Recommendation Report for Planning Permission

REF NO: F/22/21/PL

LOCATION: Land rear of Paynters Croft
Burndell Road
Yapton
BN18 0HR

PROPOSAL: 23 No dwellings with associated access, infrastructure, landscape and open space (resubmission following F/5/21/PL). This application is a Departure from the Development Plan & is in CIL Zone 3 and is CIL Liable as new dwellings.

Drawing Status		PLANNING	
Client		Driftstone Developments Ltd	
Project		Land off Burndell Road Yapton, West Sussex BN18 0GB	
Drawing Title		Existing Topographical Survey & Flow Routes	
Scale	Date	Drawn By	Checked By
1:500	Oct 2020	DJL	MJA
Drawing No.		Rev.	
D1906-200		A

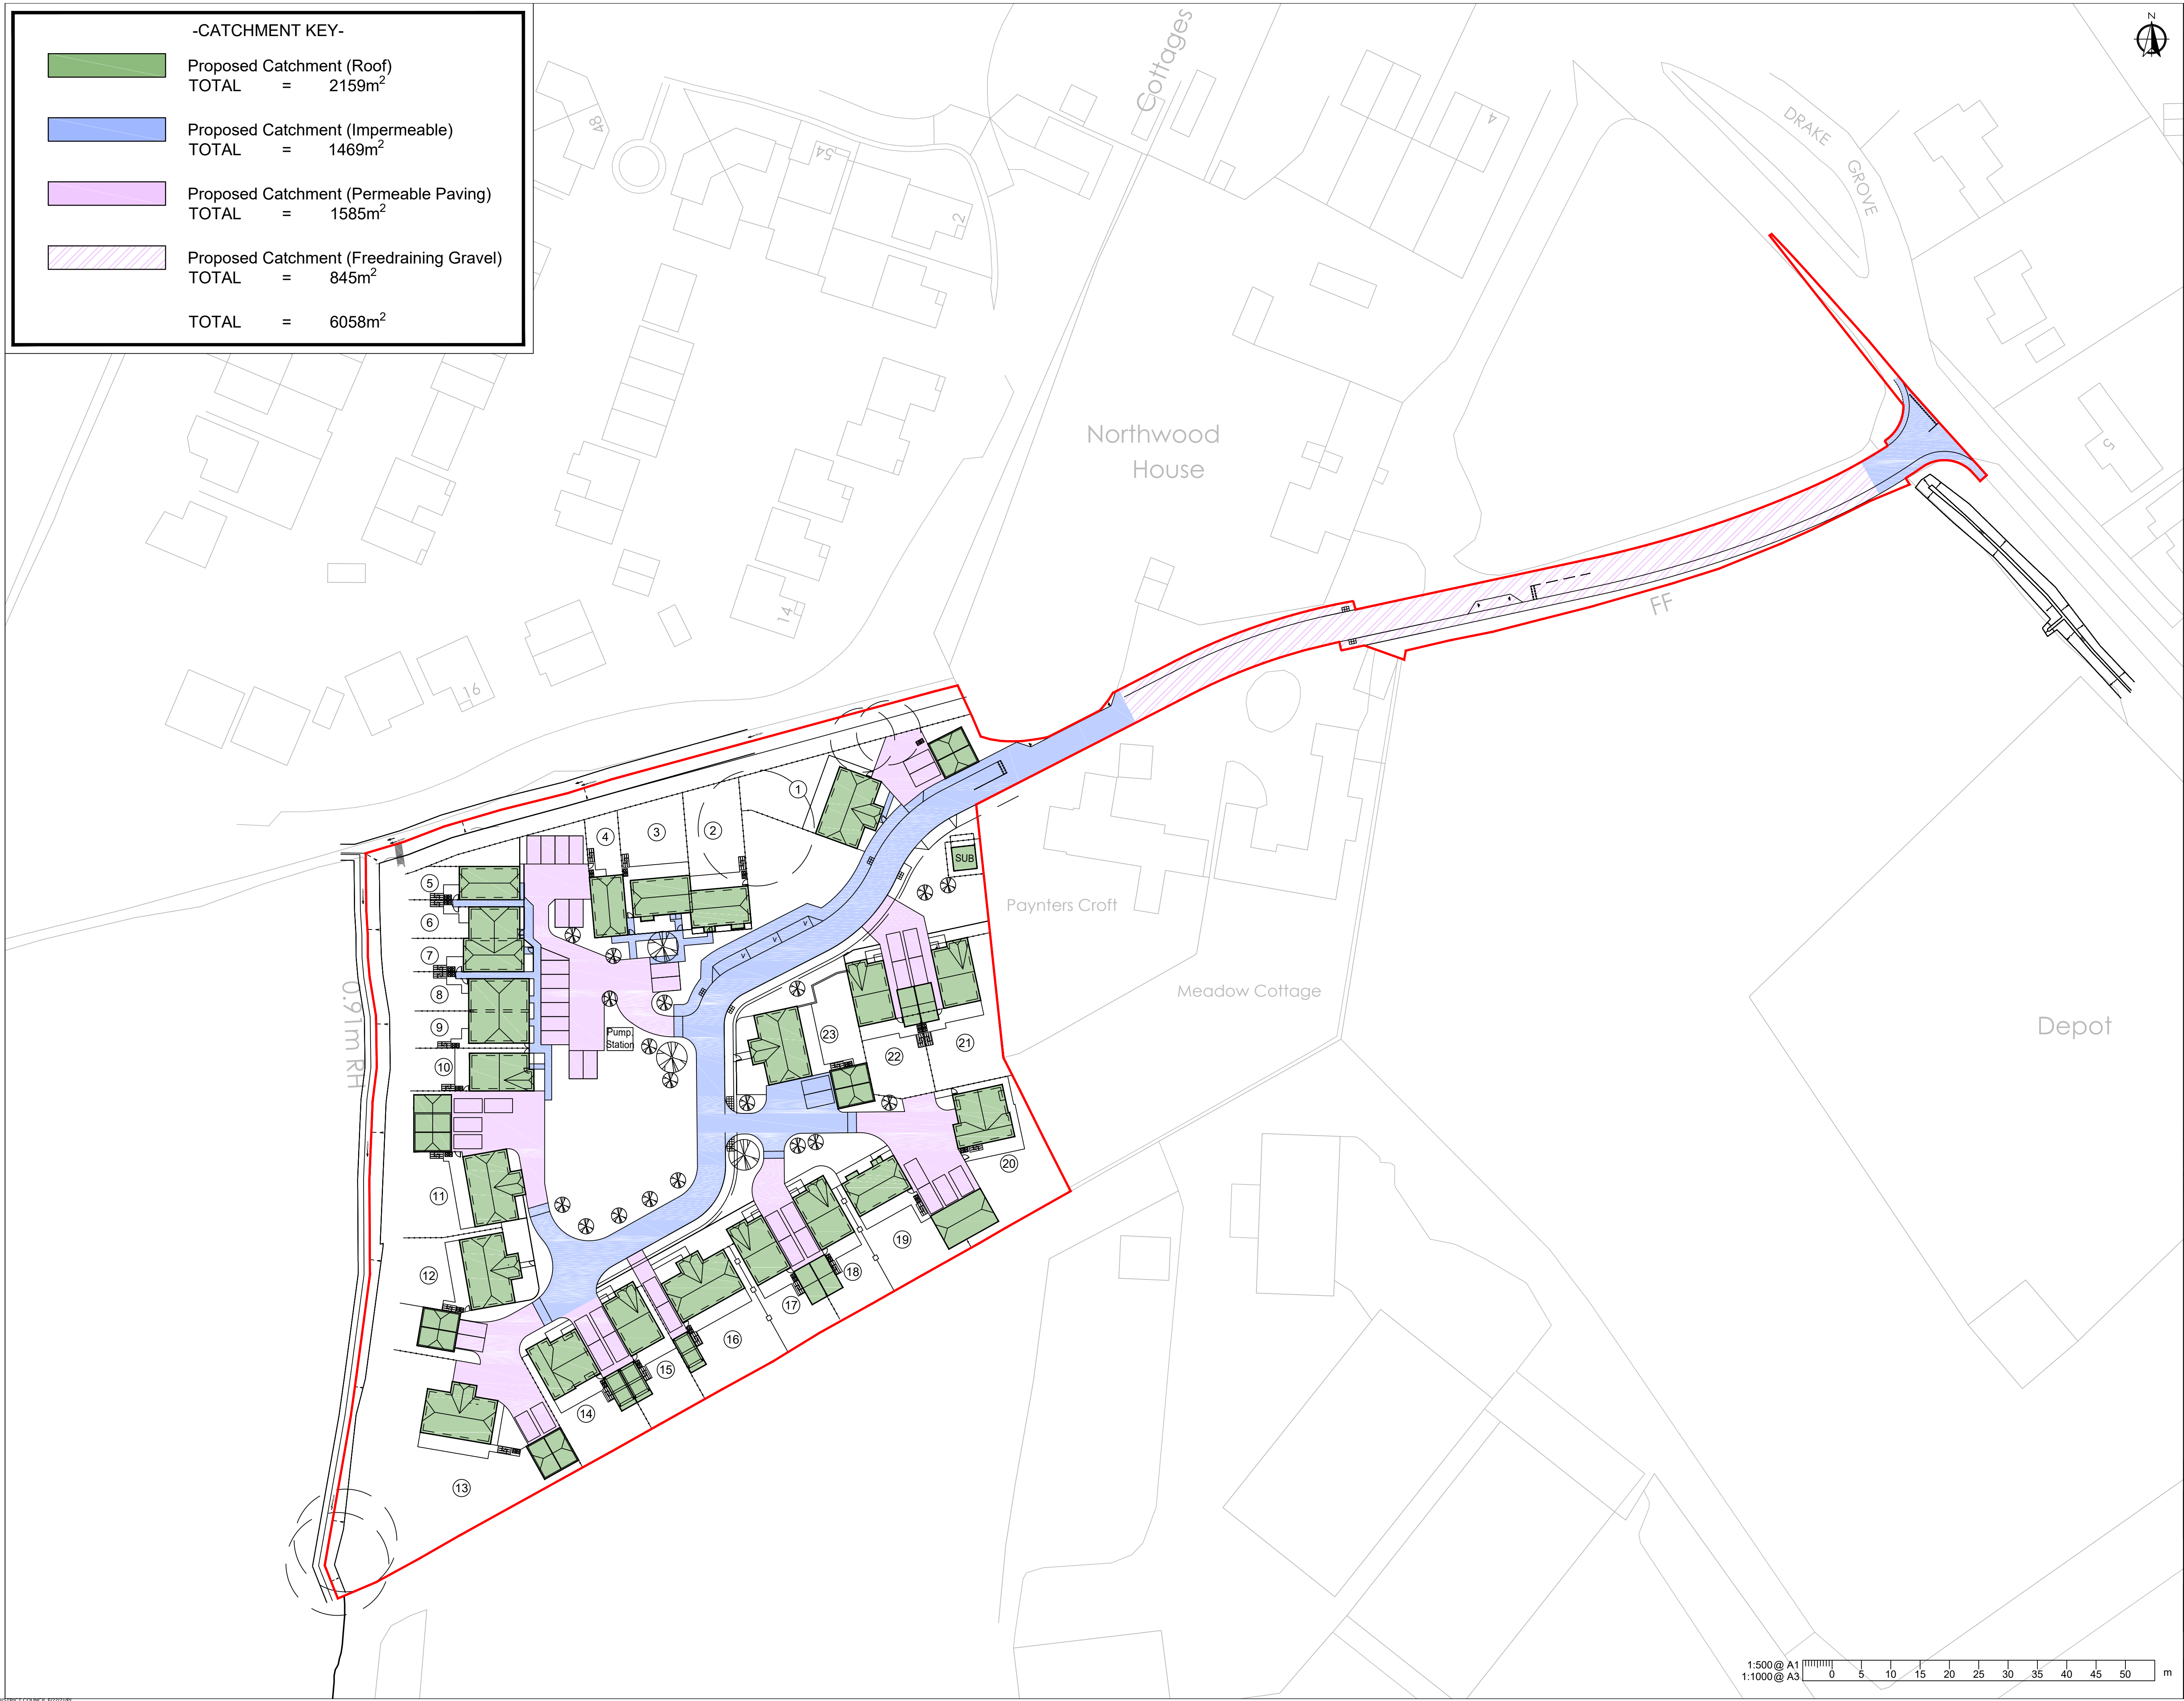
A revised drainage strategy has been submitted with proposed discharge rate reduced from that previously proposed. It is unclear how the 0.94Ha positively drained site area has been derived when the catchment plan shows 0.52Ha. Discharge rate should be kept under review as design progresses to ensure that the discharge rate takes account of the positively drained site area only. Tree root potential areas have not been provided, and a number of trees are still proposed within close proximity of the attenuation tank. Tree root potential areas should be provided, not just tree root protection areas.
